Letter of Intent

Site address: 8361 Tallman Rd; Peyton, CO 80831
Site size: 0.94 acre
Zoned: **RR1**

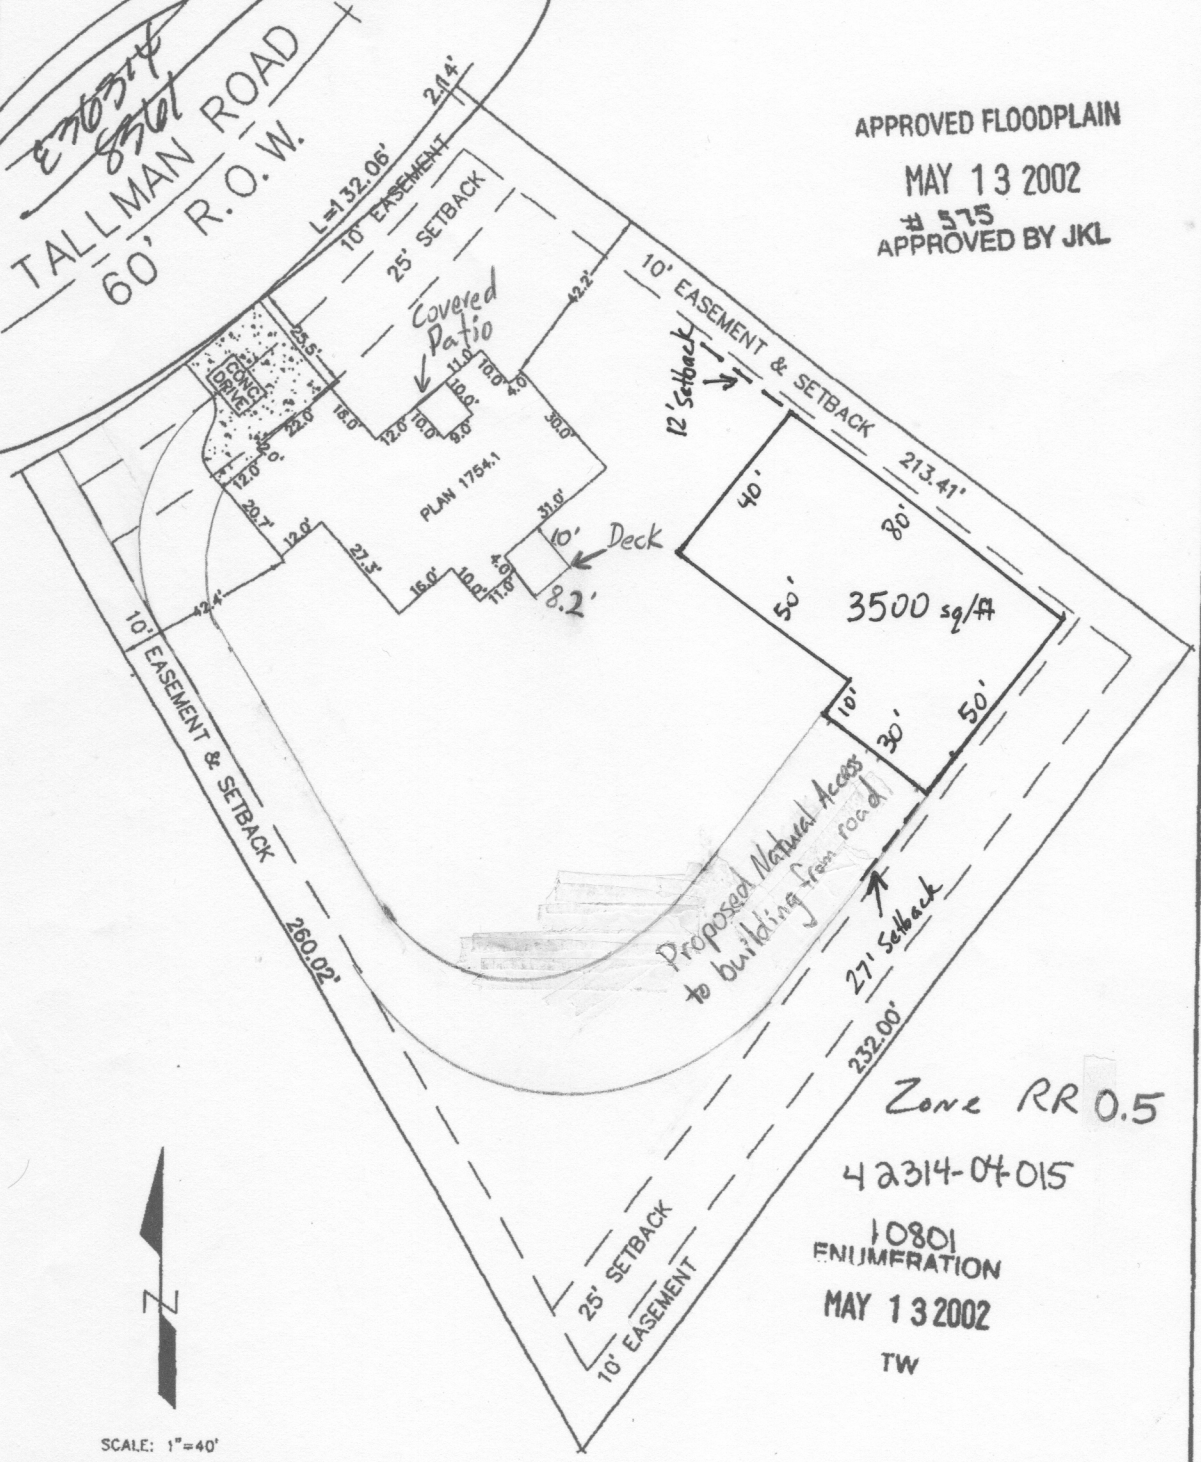
Does not match
footprint on site-plan

Does not match footprint on site-plan
